November 2, 2020

Re: COA-Westside Vehicle Maintenance/Office Bldg
18000 Cerro Colorado Road SW
Traffic Circulation Layout
Architect's Stamp 10-30-2020 (P01-D001A)

Based upon the information provided in your submittal received 10-30-2020, the above referenced plan cannot be approved for Building Permit until the following comments are addressed:

SHEET TITLE:
TOPOGRAPHIC SURVEY
FOR REFERENCE ONLY

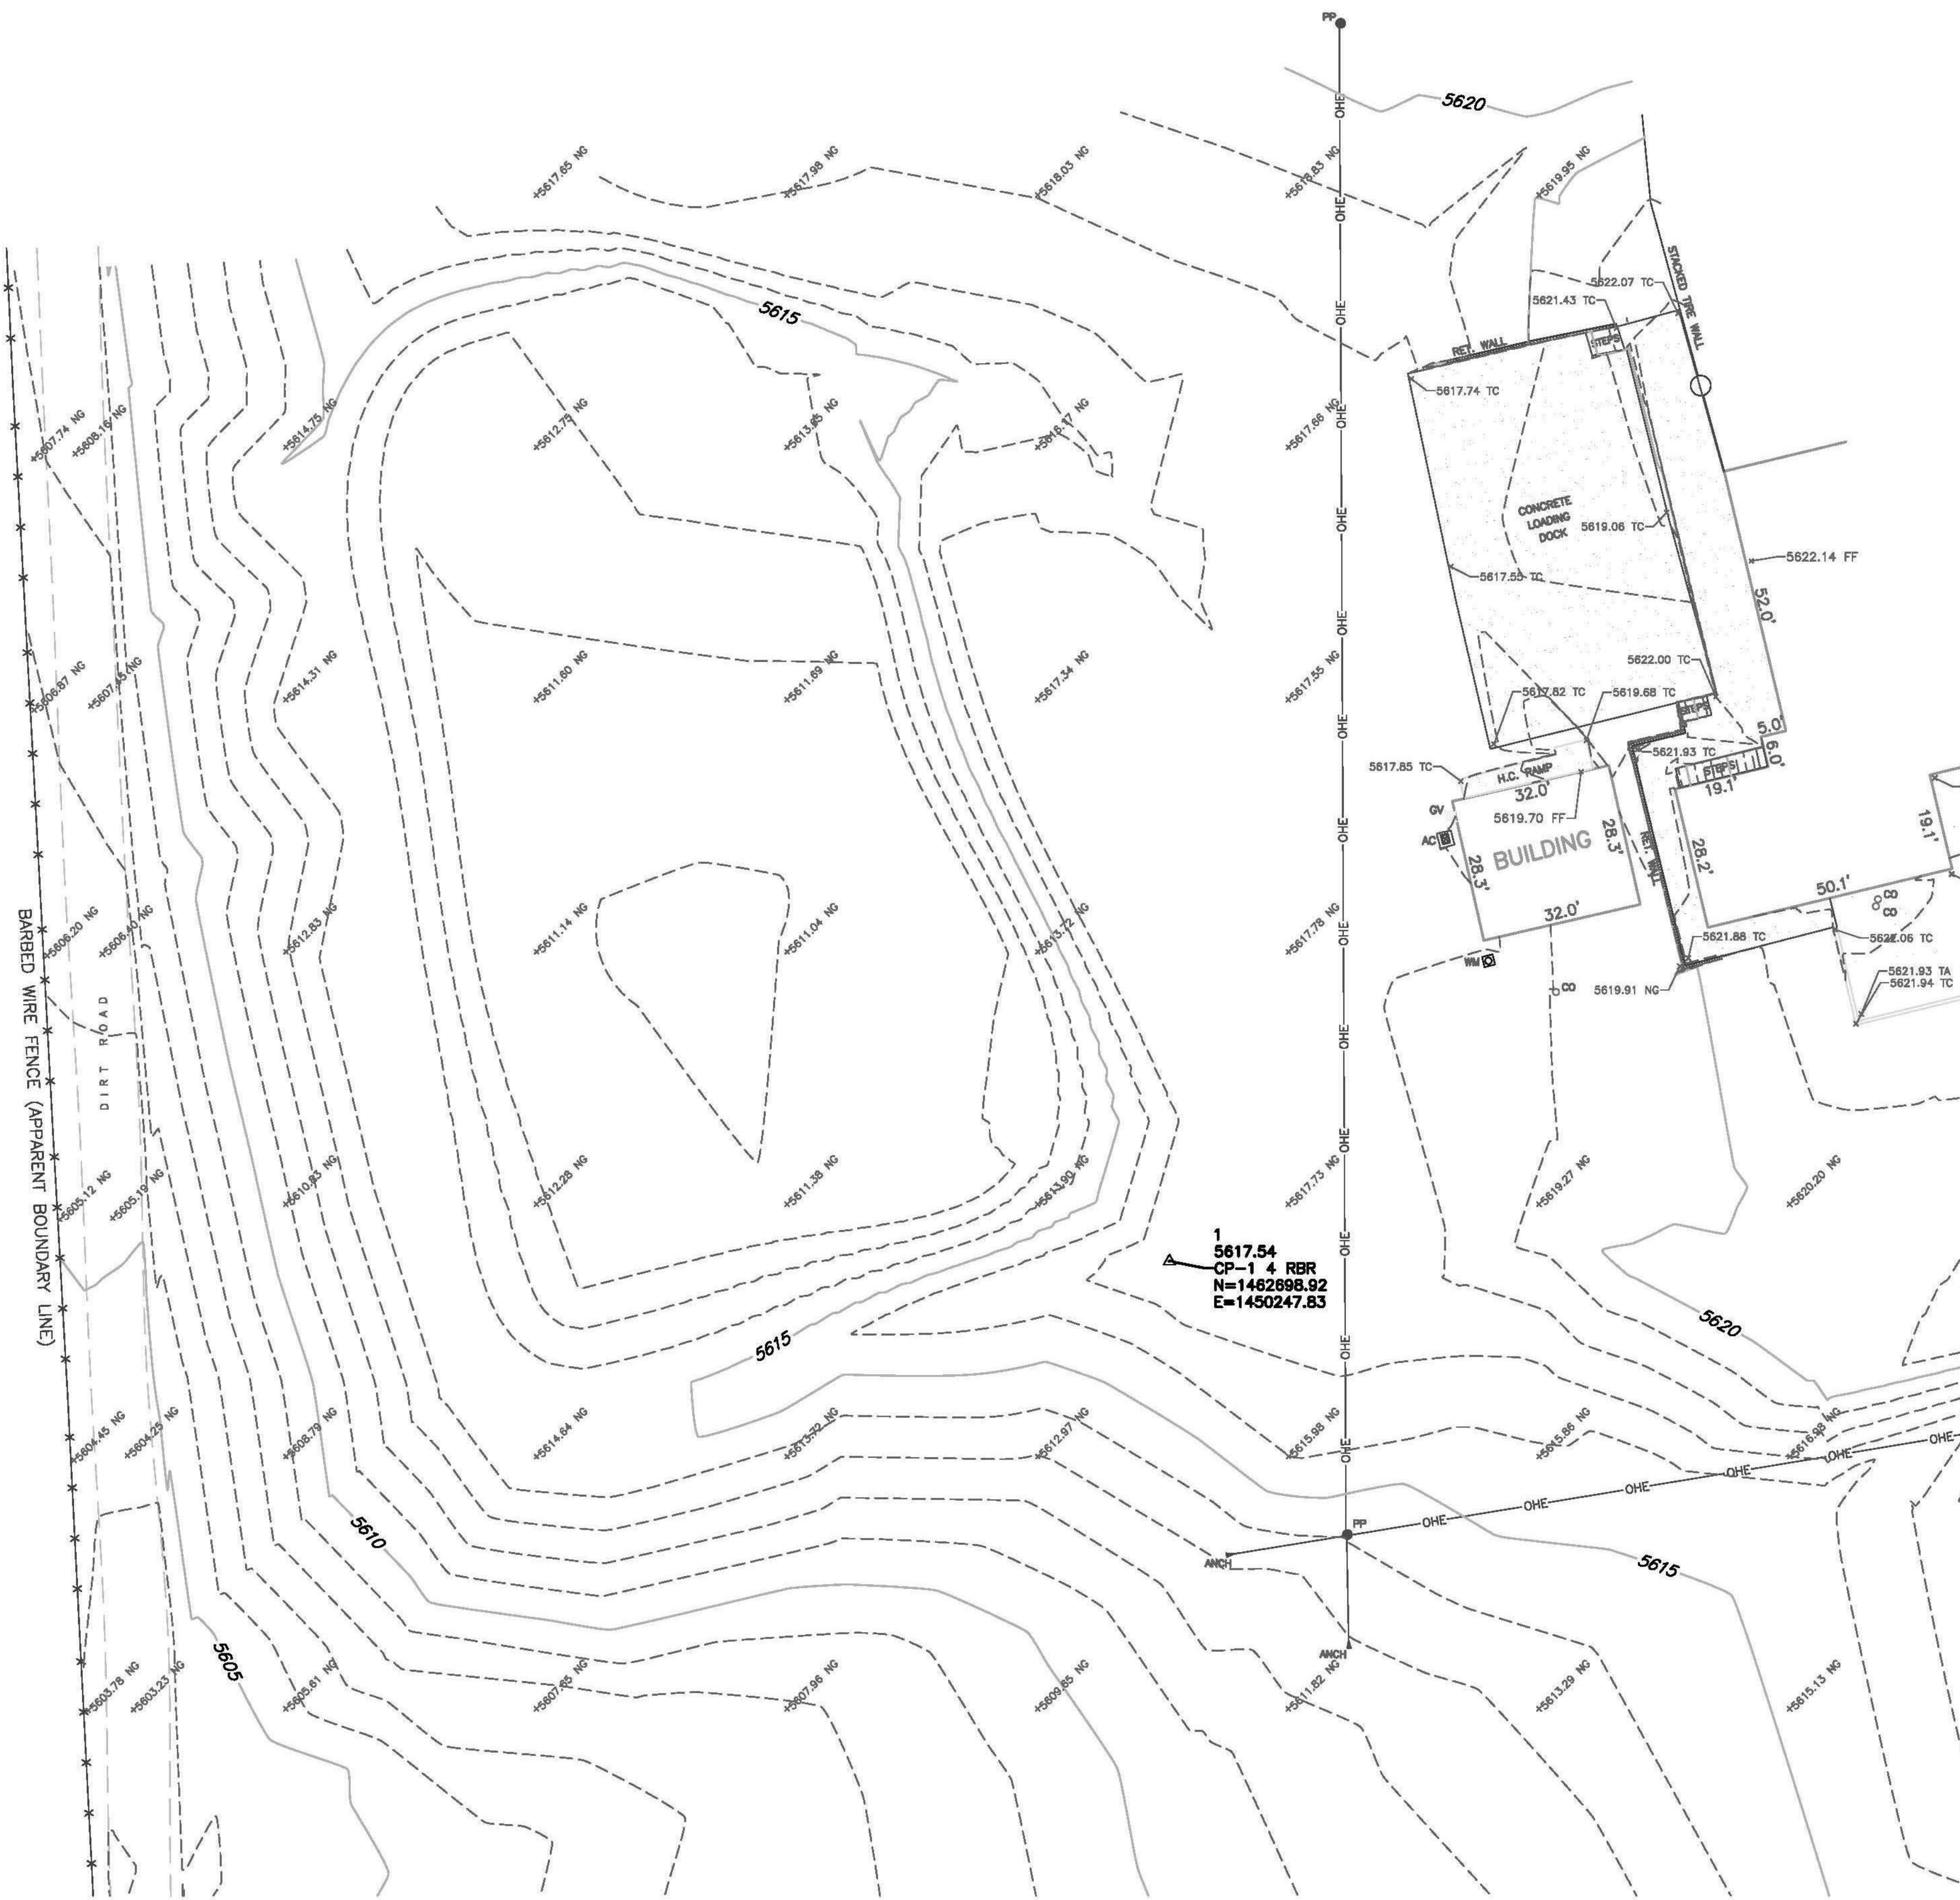
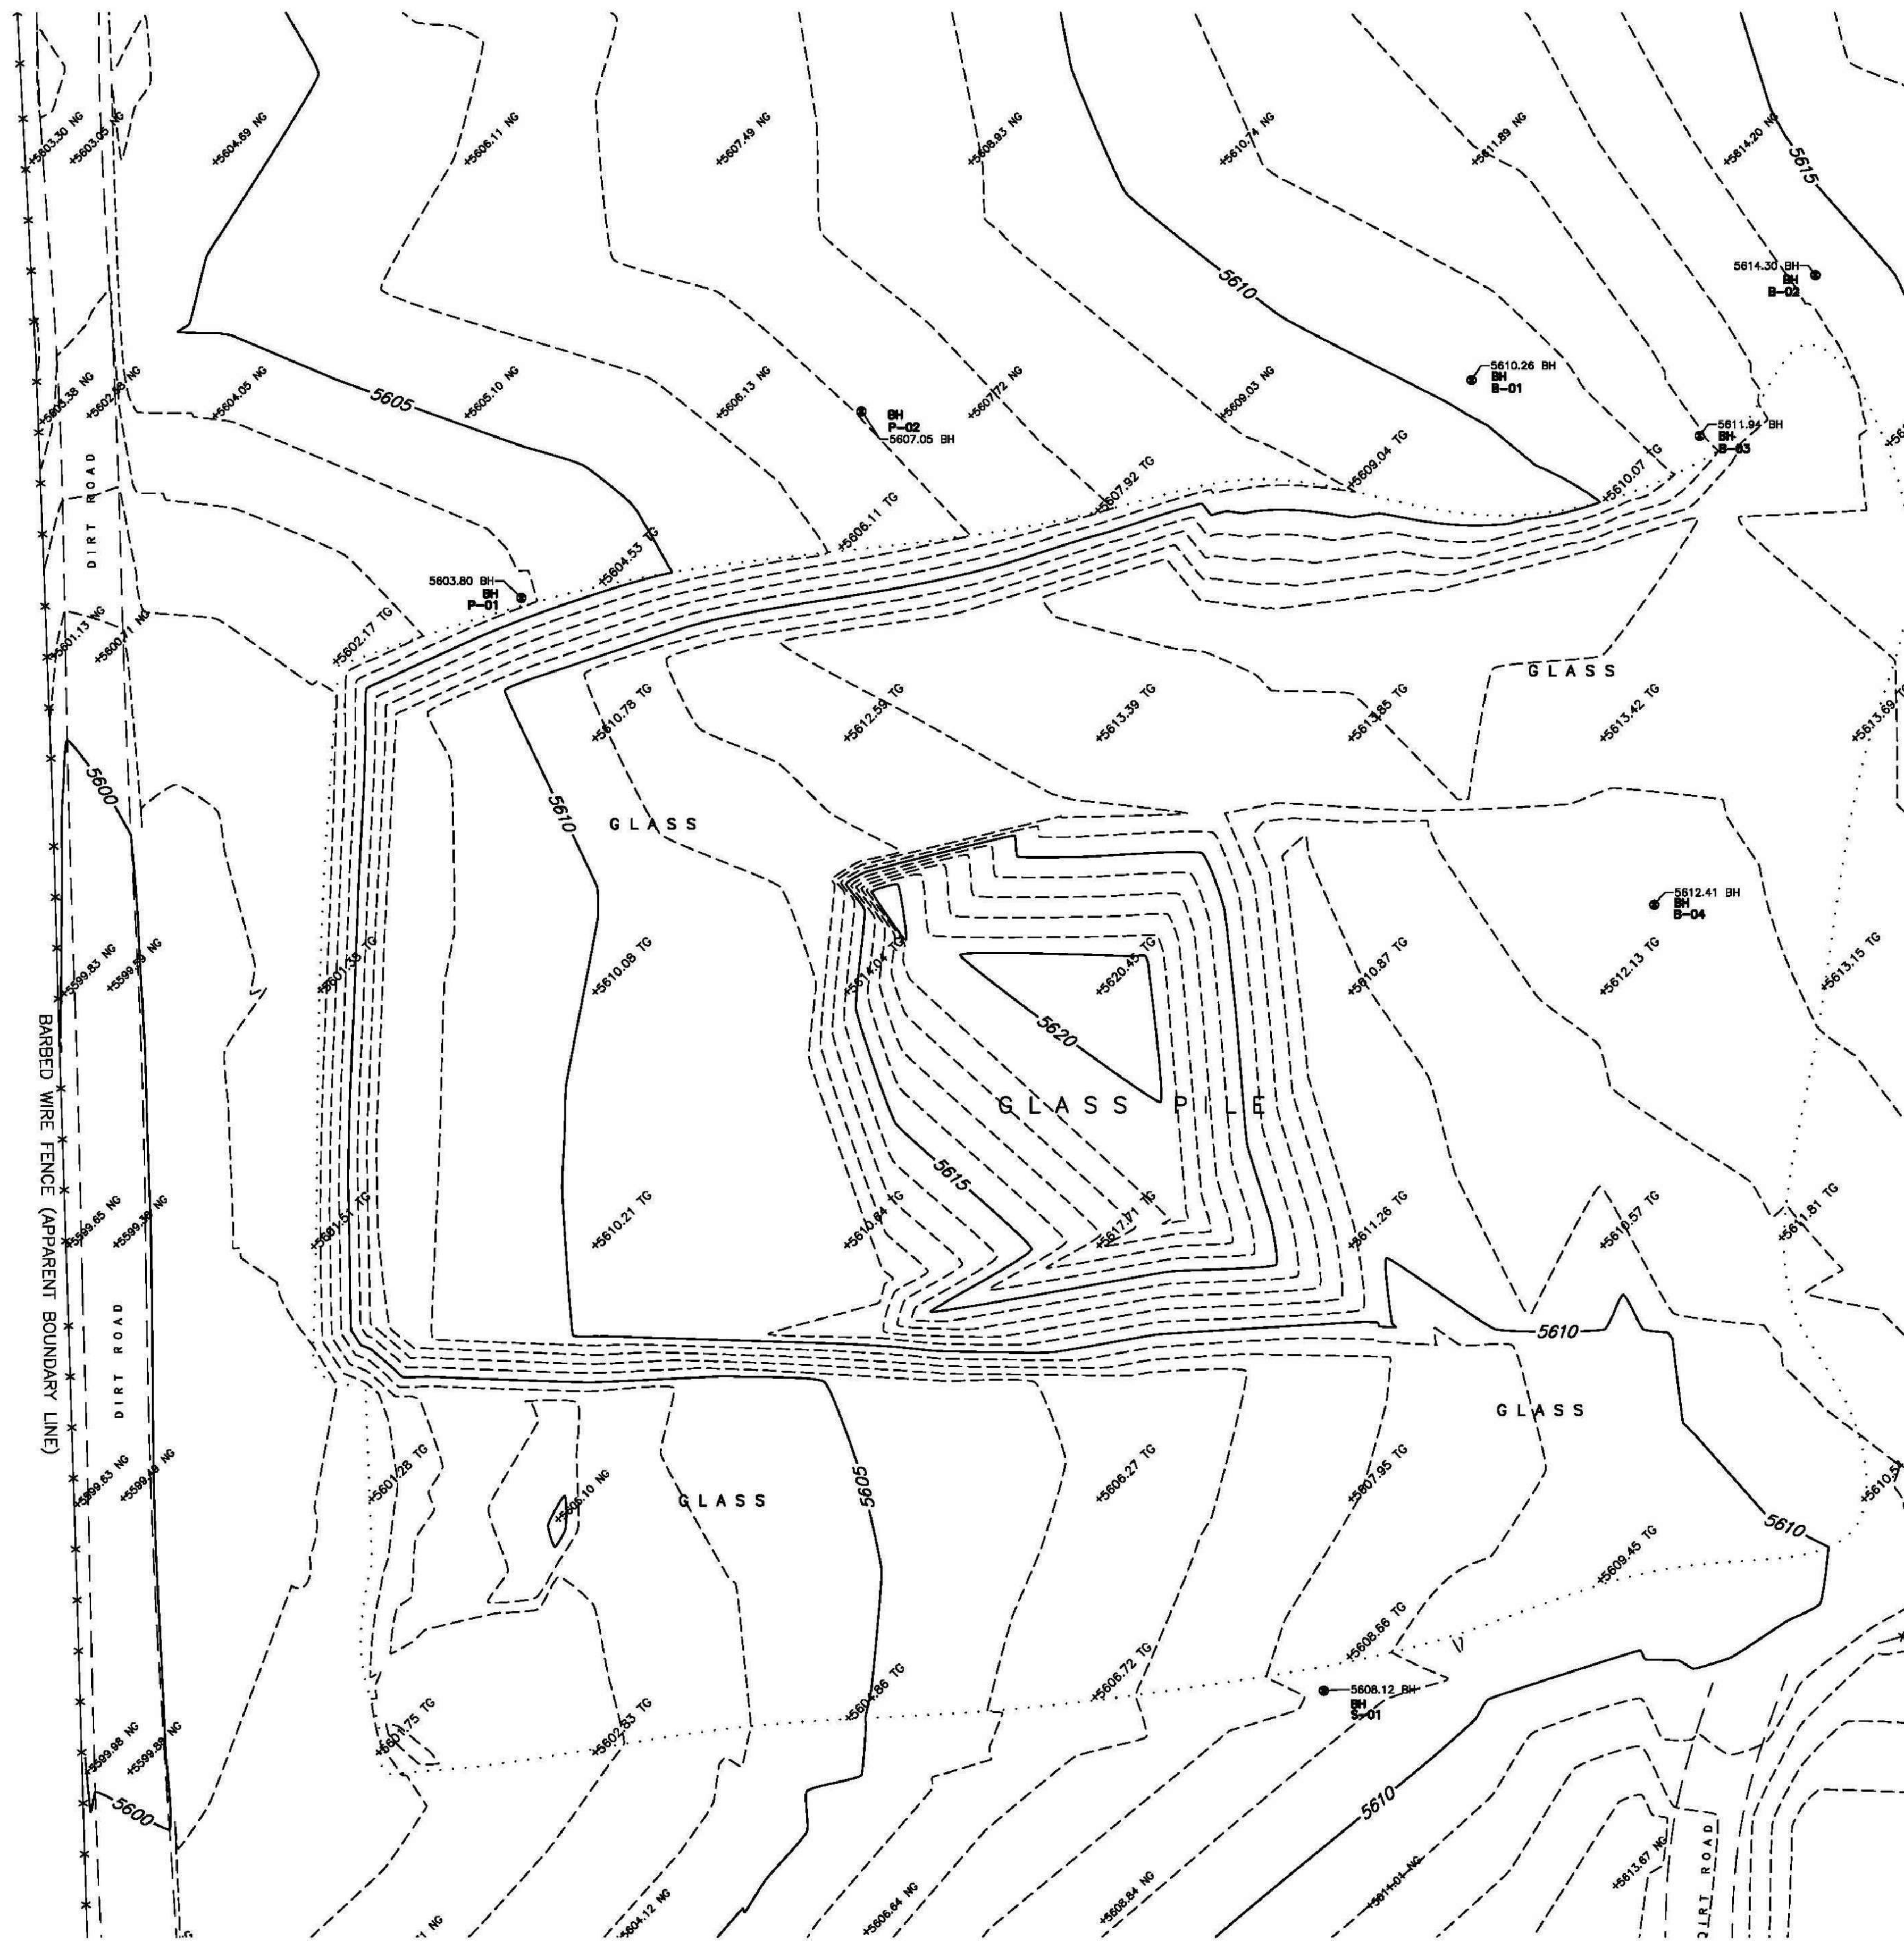
2. Site Plan: Please clean up sheet showing contour lines for your submitted TCL plan.
3. Plat Status: Please provide an approved plat if the property was subdivided for this proposed site development.
